Our ref: DOC20/664326

Senders ref: SSD 8445

Subject: Tahmoor South Project – Response To Submissions (SSD 8445)

Attachment A - Tahmoor South mine expansion- Second Amendment - Key Issues EES RTS submission 25 Mar 2020

**Figure 7 Dog Trap Creek and Dog Trap Creek Tributaries Pool Locations**

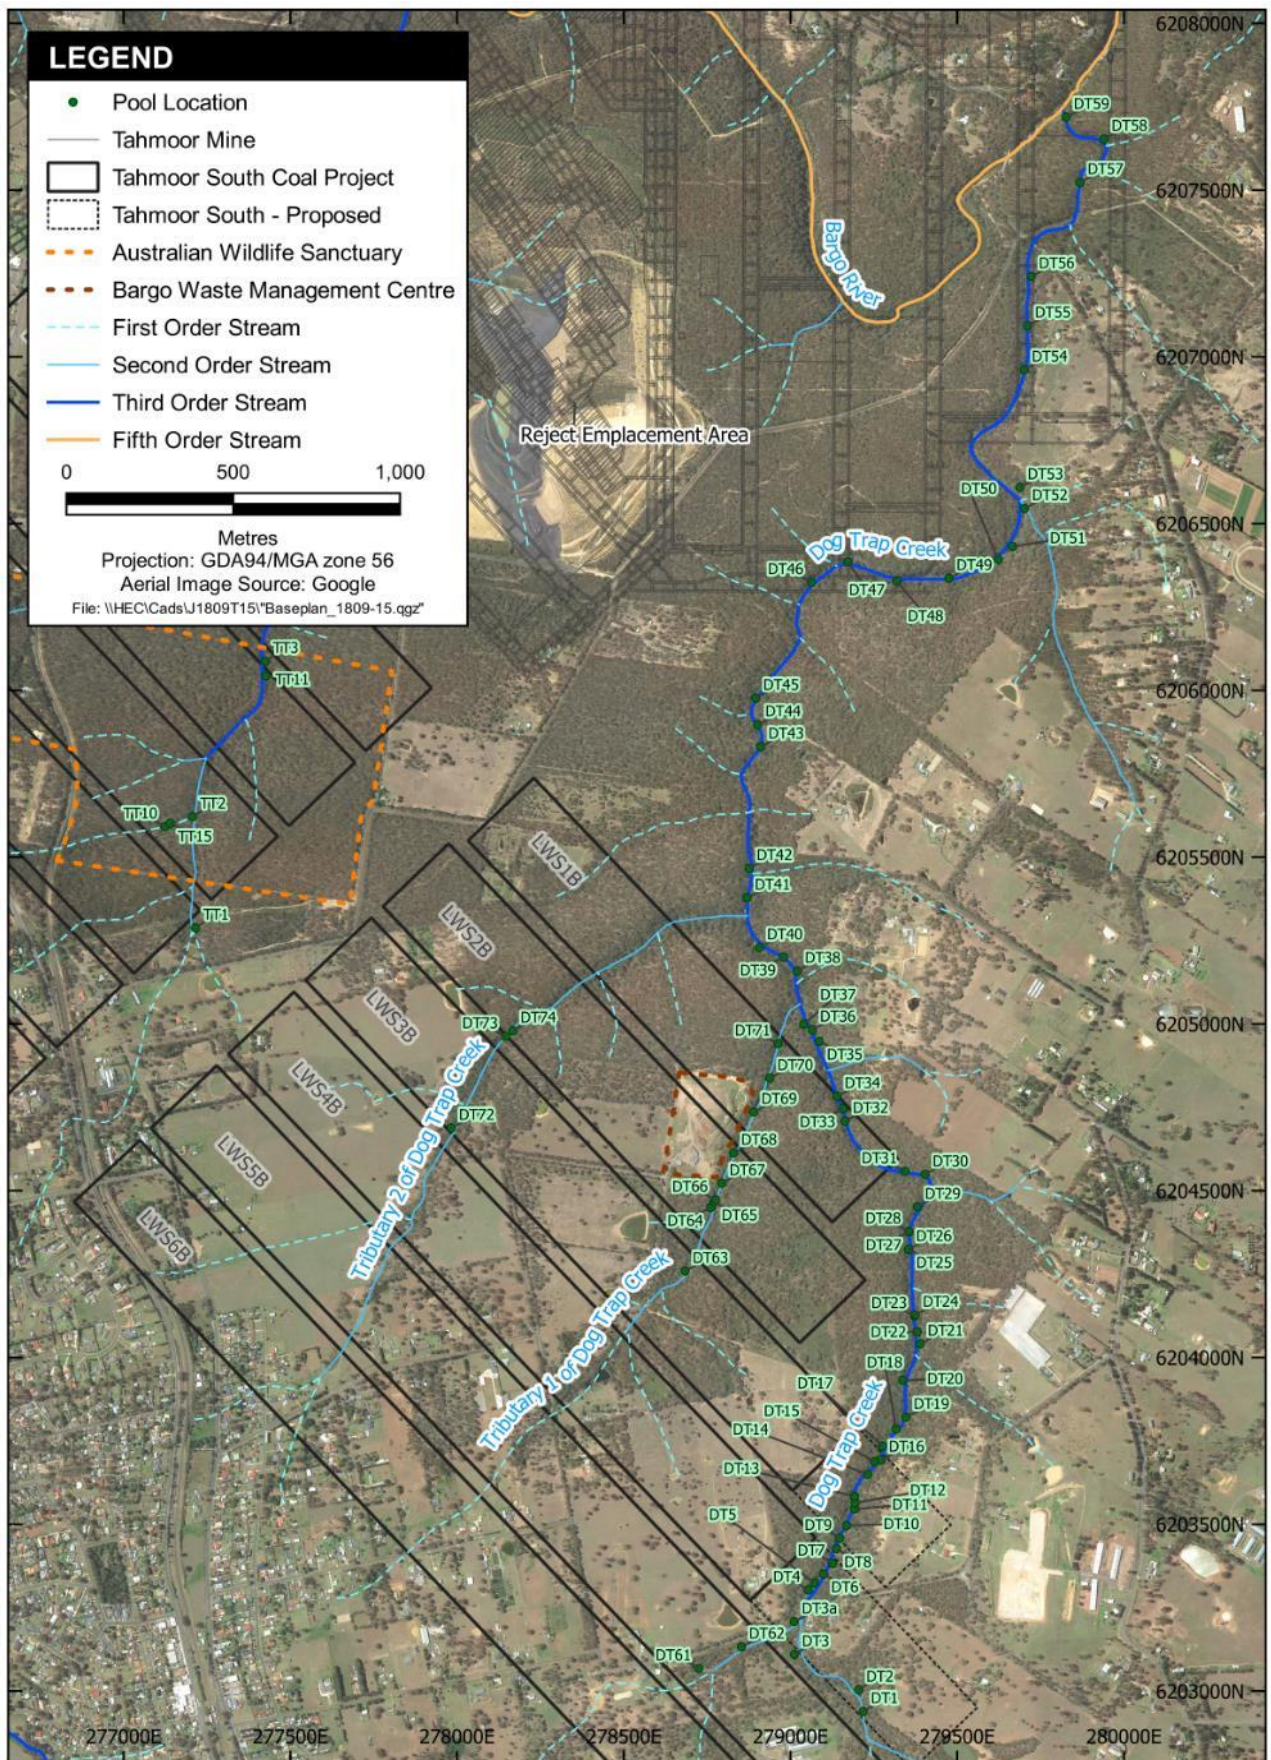
- Outstanding issues remain with the mine layout's avoidance of significant features such as 3rd order and above streams, notably in the vicinity of Dog Trap Creek and LW101B, as

detailed in our RTS submission and discussed further at Attachment A. In summary, impacts from the current mine layout upon these streams are almost inevitable and insufficient justification has been provided that these streams are repairable. As previously suggested, further reductions to LW101B would assist in reducing the risk of impact to these streams.

7	Water & subsidence	Response To Submissions	<ul style="list-style-type: none"> • Insufficient avoidance of 3rd order and above streams or cumulative impact assessment for loss 	<ul style="list-style-type: none"> • The removal of LW107B & 108B will avoid some impacts upon some 	<ul style="list-style-type: none"> • Impacts to 3rd order Dog Trap Creek pools and flow will be almost inevitable given the proposed mine layout. Once impacted, Dog Trap 	No

**Figure 8 Tahmoor Mine Licenced Discharge Points**

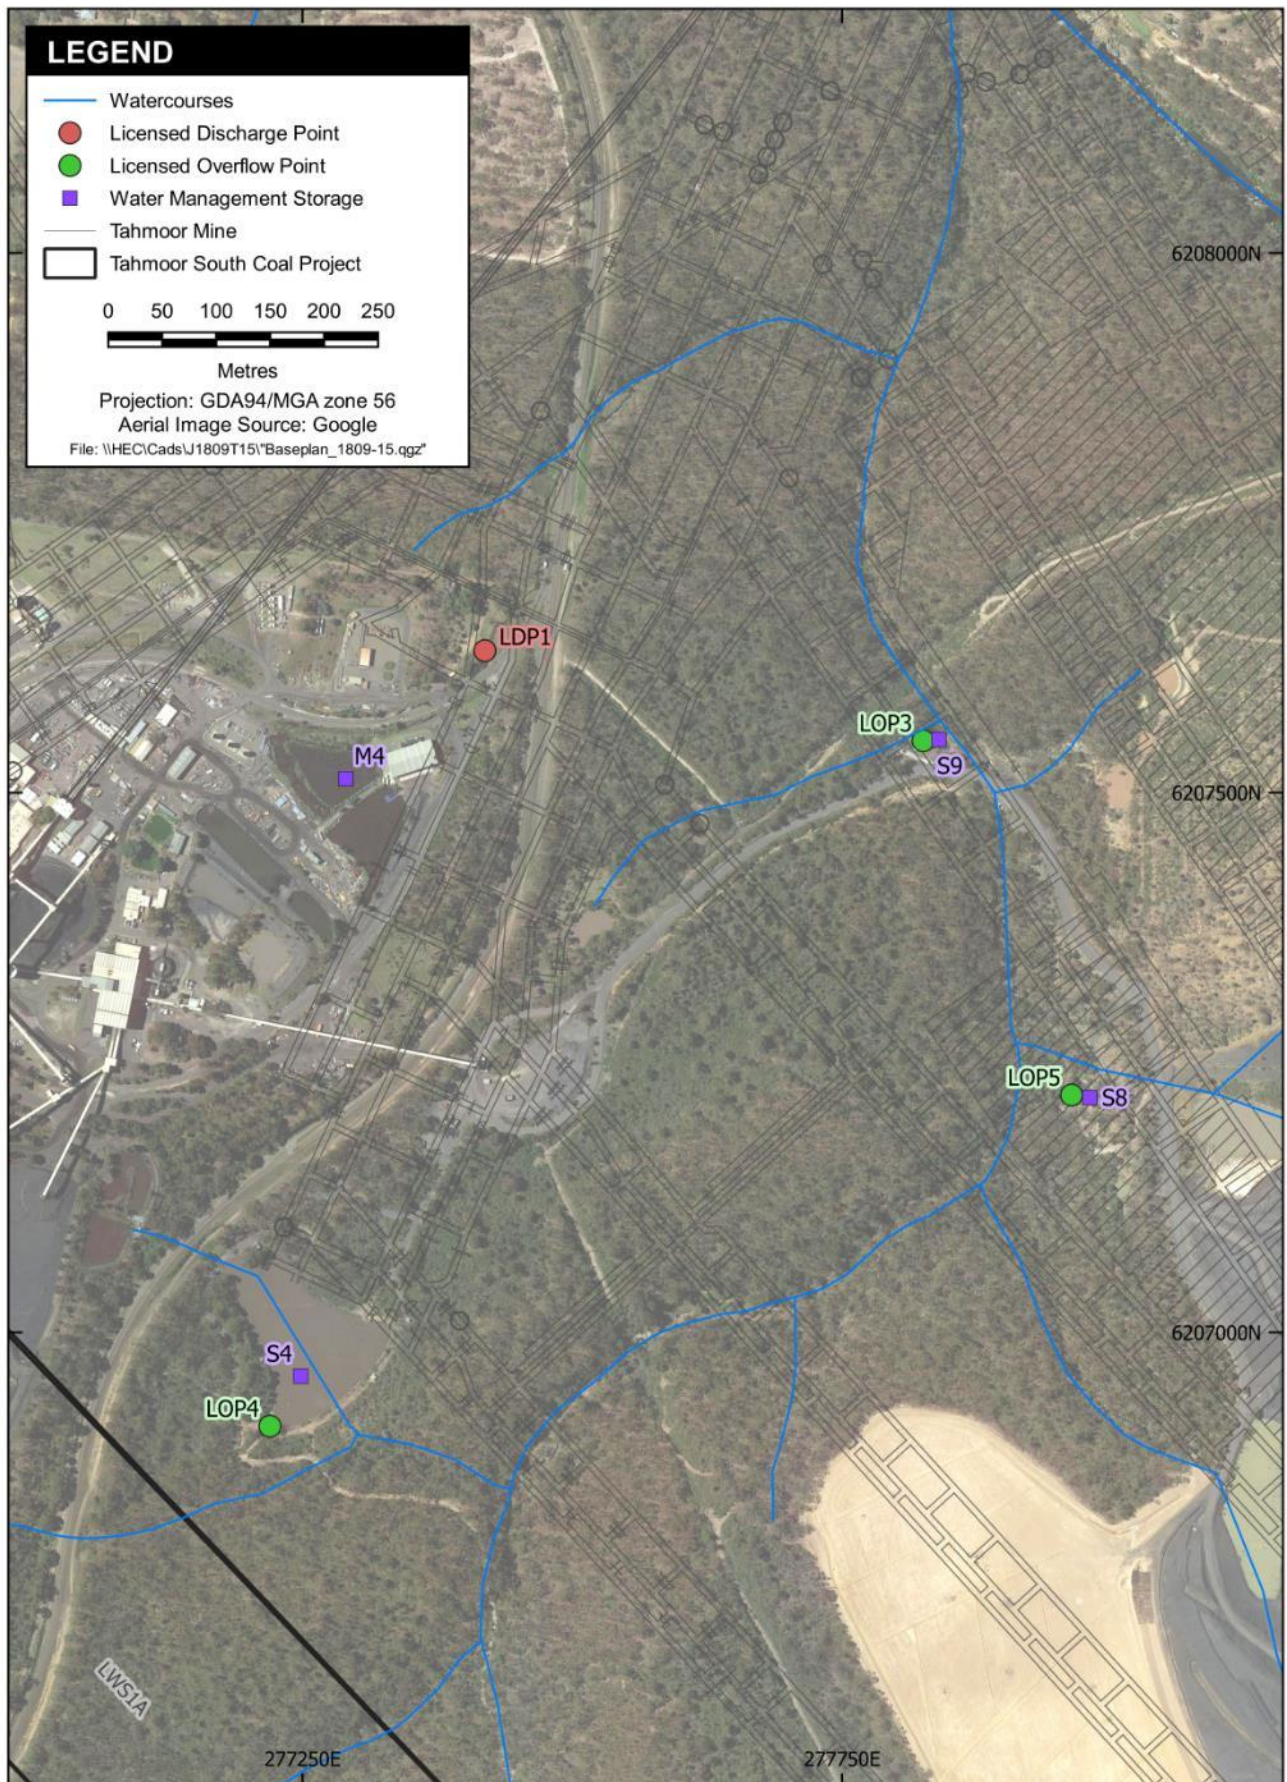
Issue No.	Description:	Extent and Timing:	RTS comment:	Second amendment response:	EES Comment:	Response satisfactory:
			<p>of water/flow to the Upper Nepean River catchment.</p> <ul style="list-style-type: none"> • Recommend considering further amendments to the layout to reduce the fracture, drainage and permanent impacts to 3rd order streams. • Consider avoiding impacts to the sections of the project undermining 3rd order streams • Although further information was supplied in the RTS regarding the adopted remediation plans for Redbank and Myrtle Creeks, it has not been demonstrated to date that these areas can be successfully remediated. 	<p>overlying streams in this section of the project footprint.</p> <ul style="list-style-type: none"> • No changes to LW101B & 103B in the vicinity of Dog Trap Creek are proposed. • Additional raw modelling data has been supplied to EES following lodgement of the second amendment report. • Additional work has been undertaken as follows: <ul style="list-style-type: none"> ○ Sensitivity analysis on Redbank Ck catchment ○ Extrapolation of baseflow loss to Nepean River 	<p>Creek is unlikely to be repairable or continue to flow in the area of mining (except after heavy rain).</p> <ul style="list-style-type: none"> • Insufficient justification has been provided to demonstrate that impacts to undermined streams and watercourses, notably 3rd order streams Dog Trap Creek, will be repairable. • To date the proponent has not demonstrated that “no flow loss” to Redbank Creek (or other streams impacted by mining) will occur due to inadequate experimental design of monitoring (eg. significant lack of appropriate baseline data). • The second amendment report does not provide a proper assessment of the ongoing impact of mine wastewater on the receiving environment, or how this will be improved in the future if the Tahmoor South proposal is approved. • Mine wastewater is currently discharged into Tea Tree Hollow (where a barium precipitate appears
